Bramford to Twinstead Reinforcement

**Document 8.9.5 (B): Temporary and Permanent Access Technical Note
– Suffolk County Council**

**Final Issue B
February 2024**

### AB-AP5

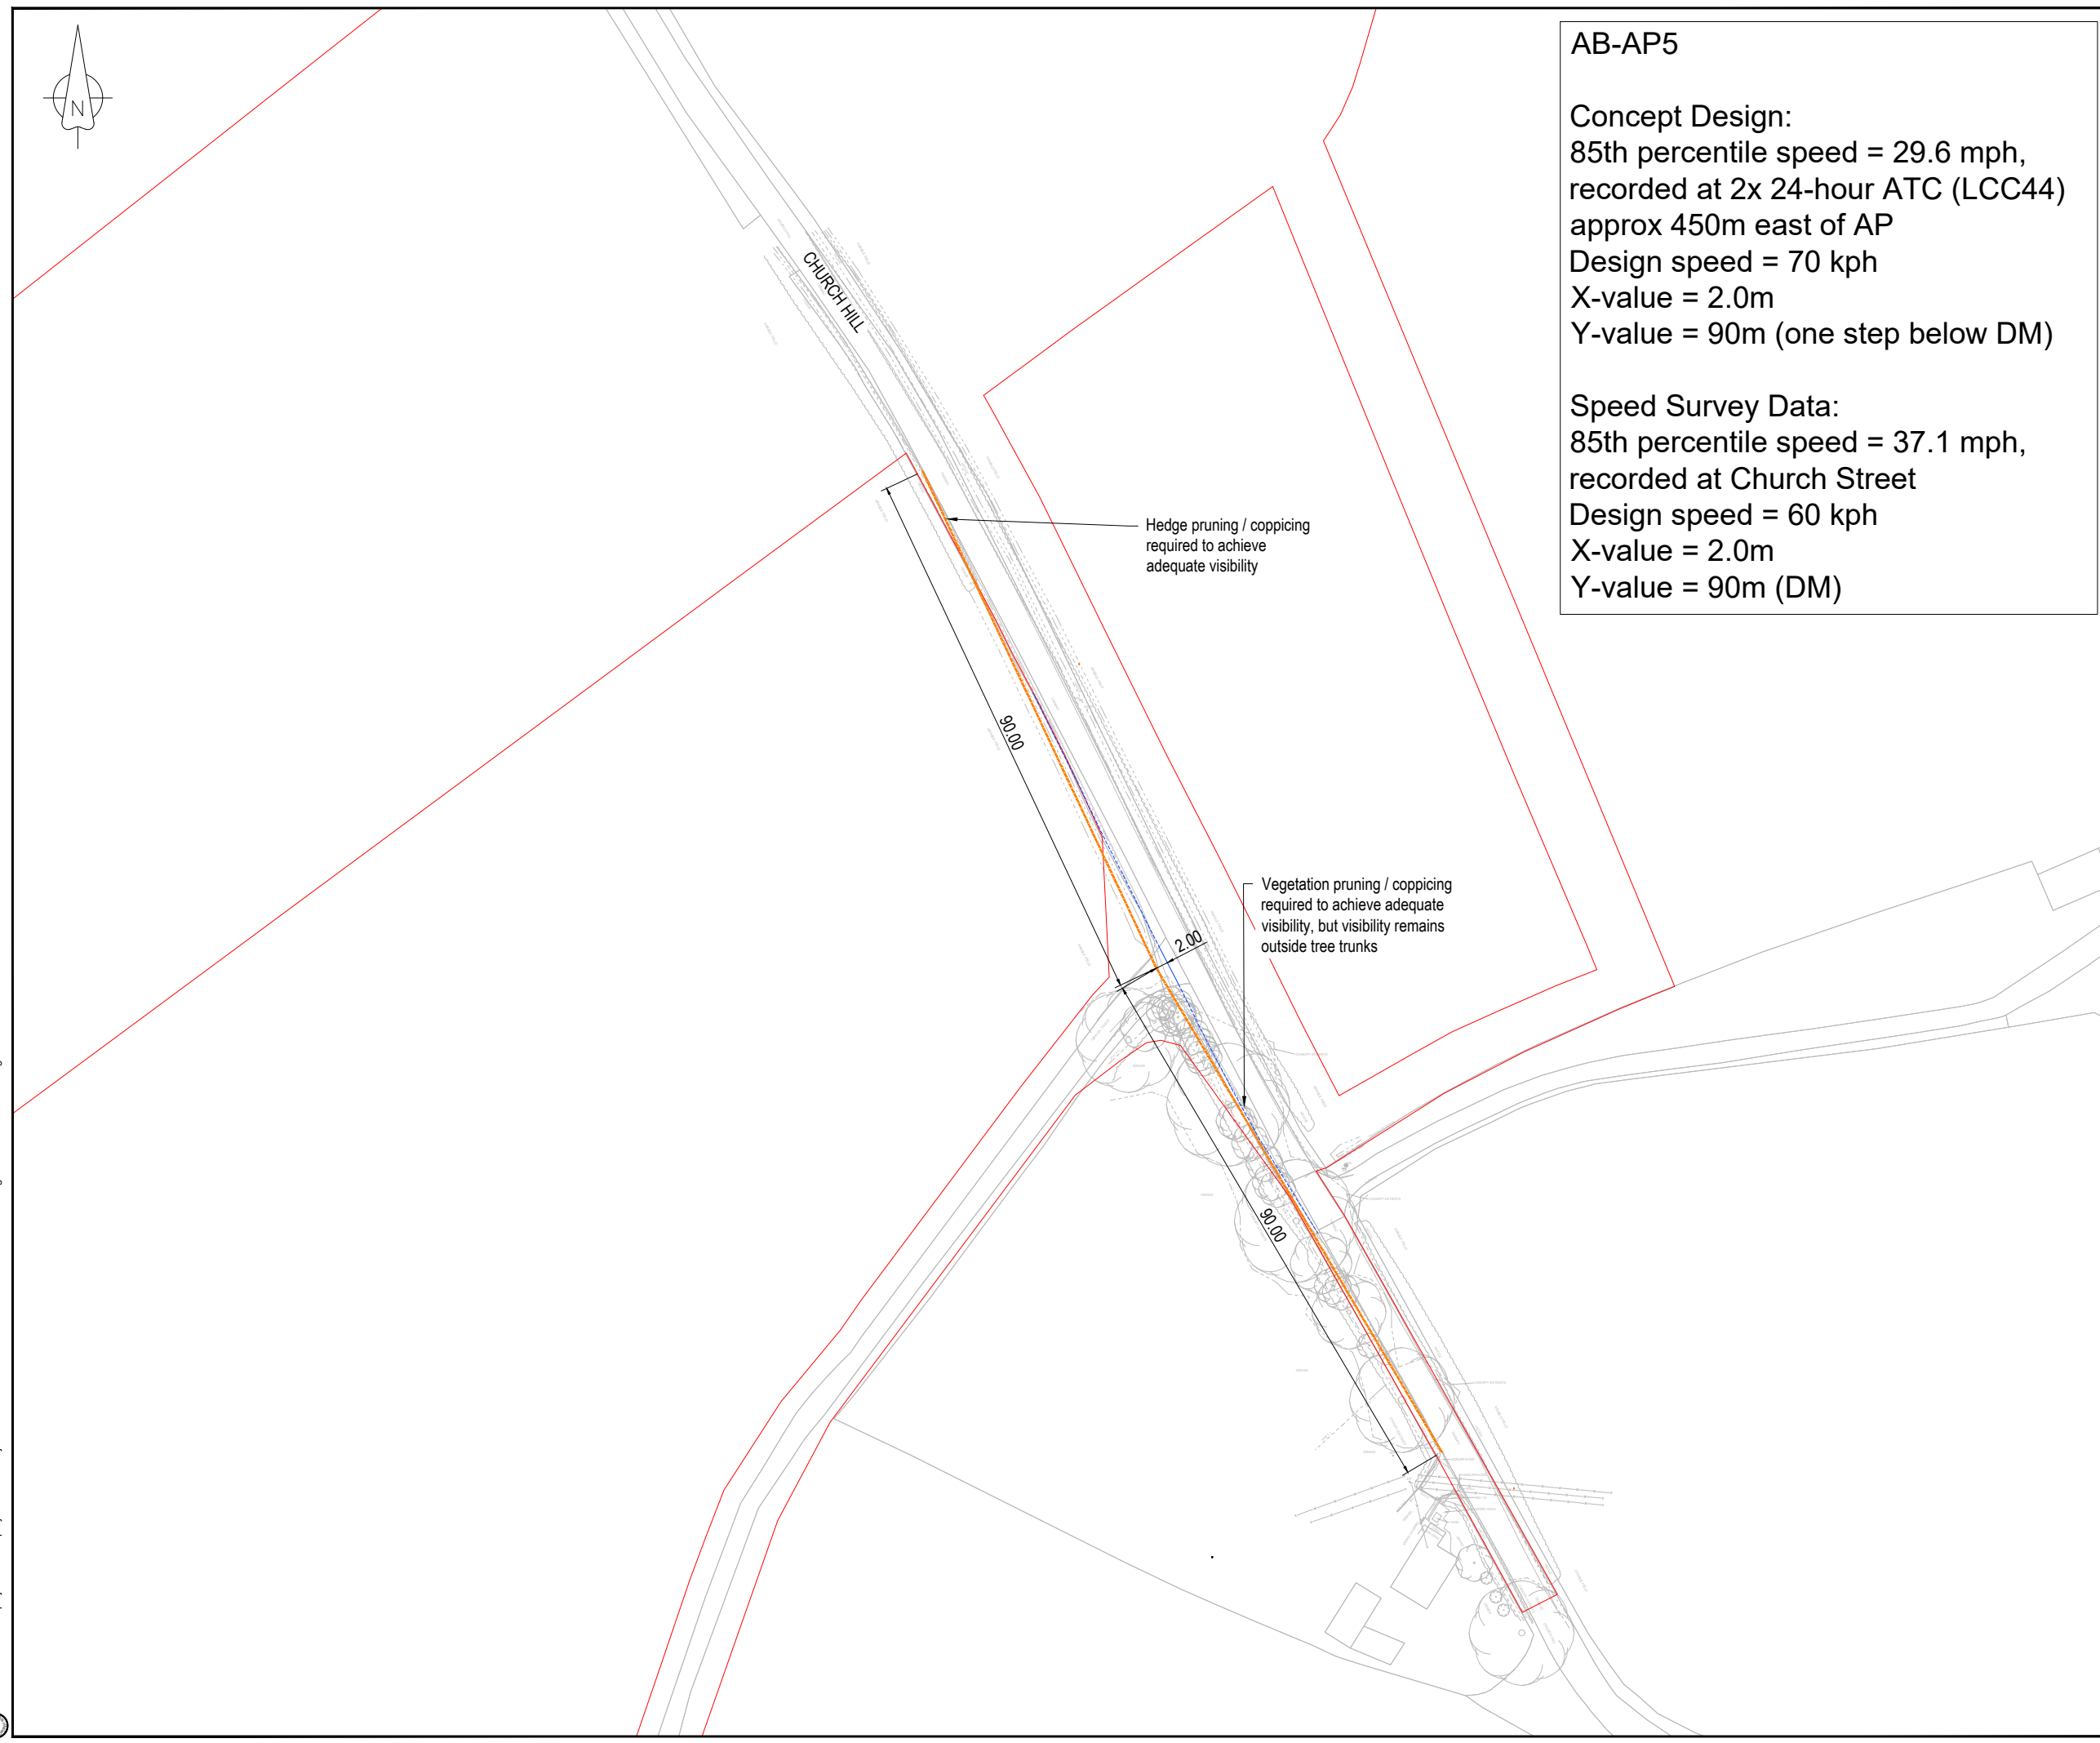
- 2.1.3 AB-AP5 is located north of a bend in the road, which is considered likely to reduce vehicle speeds at the access point and means that visibility to the south of the access point is limited primarily by the curvature in the road rather than by vegetation. The Applicant has drawn a visibility splay based on nearby traffic survey data, indicating that 70kph is the expected upper limit of the 85th percentile design speed, yielding a y-value, or distance along the major route of 90m (one step below the desirable minimum stopping sight distance). The Applicant has also considered the National Highways Design Manual for Roads and Bridges (DMRB) CD 123 – Geometric design of at-grade priority and signal-controlled junctions cl. 3.8, and proposes a x-distance of 2m which is appropriate for direct accesses. The x-distance is the distance away from the carriageway edge where the viewpoint of a driver of an emerging vehicle is positioned.

- 2.1.5 The visibility splay shown in Appendix A requires the coppicing and pruning of vegetation within the functional highway to achieve the dimensions set out above, but the topographic survey has shown that the visibility splay does not interact with any surveyed tree trunks. Speed surveys are being carried out in January 2024 to confirm that the 70kph 85th percentile assumption is appropriate. Assuming that the speed surveys confirm assumptions to date, the visibility splays shown in Appendix A are considered appropriate. If the speed surveys show greater speeds than expected, the visibility splay shown would be revisited to determine whether a greater splay would be required or an alternative mechanism introduced to deliver an appropriate access.

- 2.1.8 A speed survey was commissioned in January 2024 at this location to confirm the 85th percentile design speed assumption was appropriate. The speed survey was carried out at this location because the data collected previously was not sufficiently close to the access and as a result of concerns raised about this access in particular during Examination of the application. Speed survey data obtained for the project prior to submission of the application is provided in document 8.9.2 Transport Assessment Traffic Survey Data [REP7-024]. The survey was undertaken at Church Hill, in the vicinity of the access point, for a seven-day 24-hour data collection starting 10 January 2024. Table 2.1 shows the outcome of the speed survey.

- 2.1.9 The design at application was based on a design speed of 70kph based on the 85th - percentile design speed from the previous traffic survey, and a 90m stopping sight distance, which is one step below the desirable minimum. The recent speed survey revealed that the design speed based on the 85th percentile is 60kph, which is lower than the design speed assumed for the sketch in Appendix A. For a design speed of 60kph, 90m is considered the desirable minimum stopping sight distance. Therefore, the survey confirmed that the approach taken in Appendix A is appropriate and no modifications are necessary to the visibility splay in the concept design.
- 2.1.10 The design developed shows that AB-AP5 is an appropriate access and safety requirements can be achieved at this location.
